PLANNING CONSULTATION RESPONSE

Application No	2026/0354
Proposal	Erection of a residential care home consisting of 6 single bedroom self-contained units and a detached 2 bedroom respite bungalow for young adults (Use Class C2) with associated works including formation of accesses; car parking and landscaping.
Address	Land west of Cross Street, Worsbrough Dale, Barnsley
Date of Consultation Reply	23/06/2026
Consultee	Katie Lawrence, Planning Ecologist

Consultation Assessment and Justification

Landscape Plan 1:200

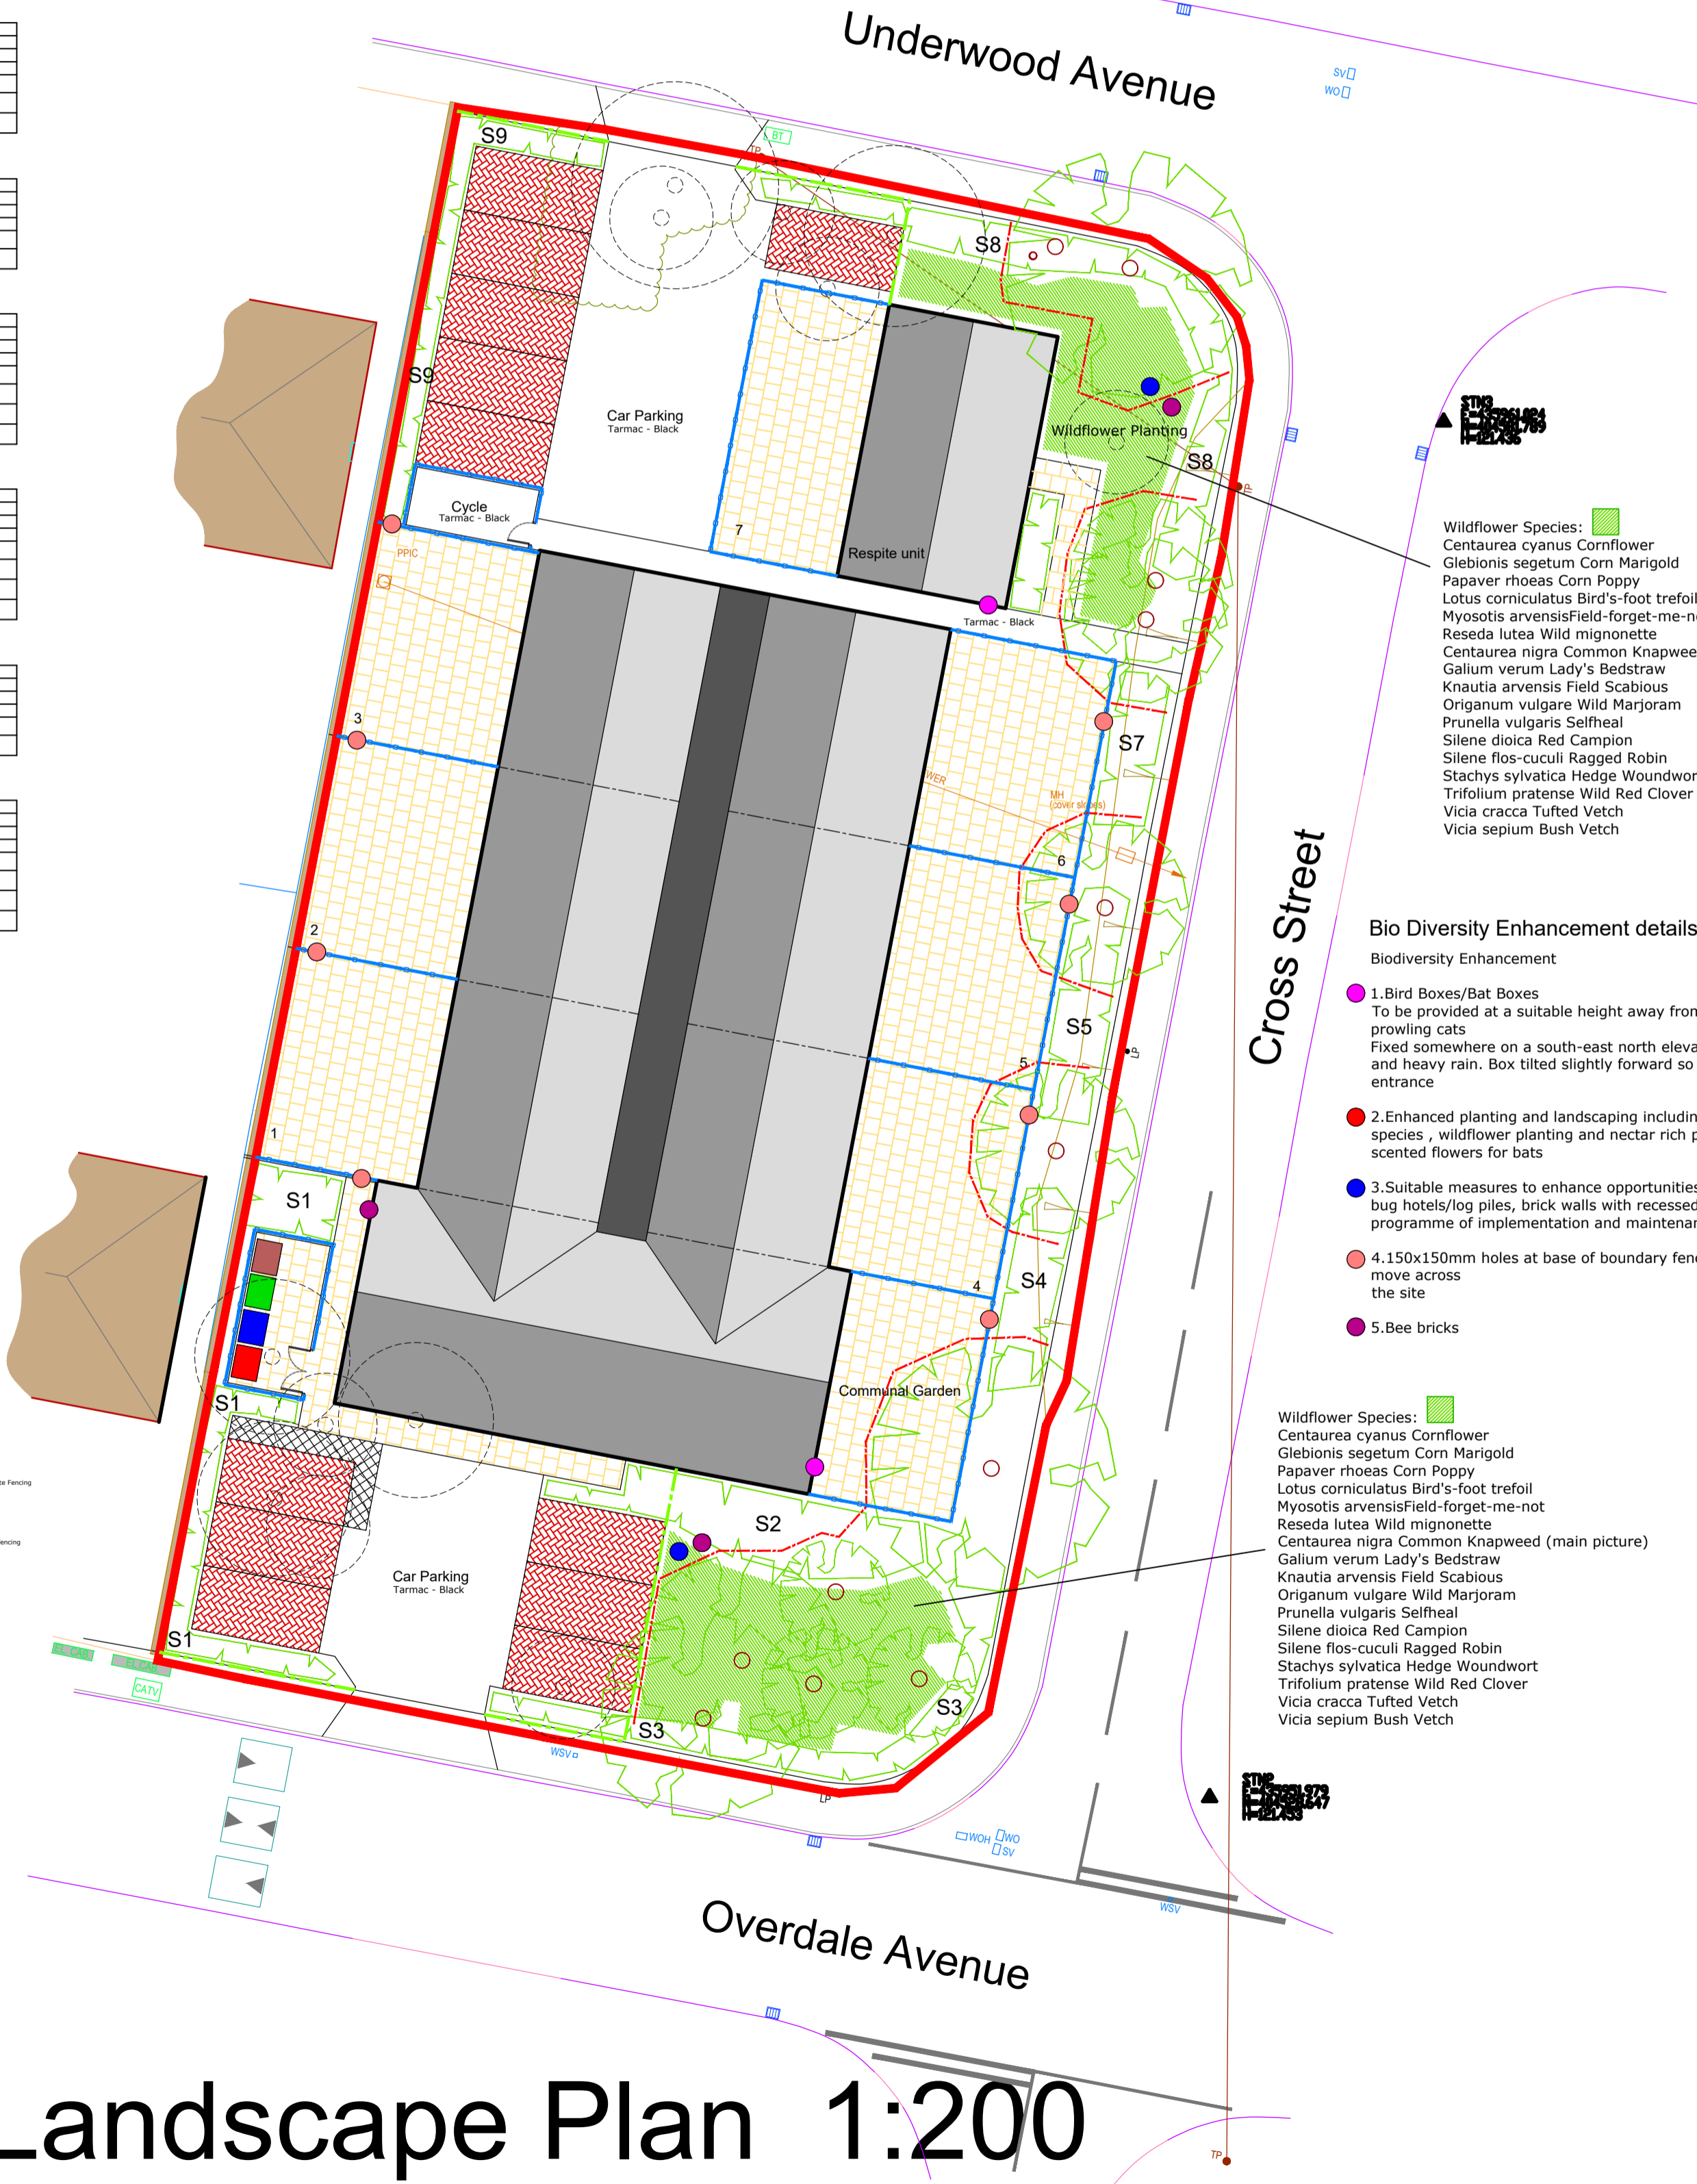
- It is noted that habitats shown on the proposed habitat map (Appendix C) within the BNG report and those shown on the landscape plan (drawing no. OD/JVND0C/2026/26.009 04) don't entirely match those input into the on-site habitat creation tab (i.e. post-development habitats) of the metric. The landscape plan shows areas of wildflower grassland proposed to the south-east and north-east corners of the site, with the plan within the BNG report mapping these as other neutral grassland to the north-east and vegetated garden to the south-east. Within the metric, no other neutral grassland habitat has been input within the habitat creation tab. I don't consider other neutral grassland to be an appropriate habitat to propose in these areas due to the likely overshadowing of these areas from surrounding retained trees. These areas may be more appropriately mapped as a low distinctiveness habitat such as modified grassland or vegetated garden. Furthermore, other neutral grassland, a medium distinctiveness habitat would be deemed a significant enhancement as per government guidance and a Habitat Management and Monitoring Plan would have to be conditioned setting out management and monitoring over a 30-year period. The LPA would also seek to charge a monitoring fee for review of the monitoring reports submitted to us over the 30-year management period. This is likely to be disproportionate to the habitat proposed. The metric and proposed habitat plan within the BNG report should be amended accordingly.

- It is noted that the trees recorded within the baseline of the metric have all been set as lost, with a zero input into areas retained and enhanced. The landscape plan shows the majority of trees to the boundaries as being retained so the metric should be amended accordingly. Trees input within the on-site habitat creation tab of the metric should be removed as the landscape plan shows no additional new tree planting.

- There are a number of shrub beds shown on the landscape plan. These have been incorporated within the metric as either non-native and ornamental hedgerow or vegetated garden. It is considered more appropriate for these areas all to be mapped as introduced shrub.

- Precautionary works recommended within the BNG report include the clearance of vegetation outside of the nesting bird season and the protection of retained trees during construction works, which is welcomed. These measures can be secured by way of a planning condition.
- The landscape plan shows bat and bird boxes installed on proposed buildings, features to be incorporated within areas of green space, such as bug hotels, etc. and gaps within proposed fencing to allow access to hedgehogs, which is welcomed. This can be secured by way of a planning condition.
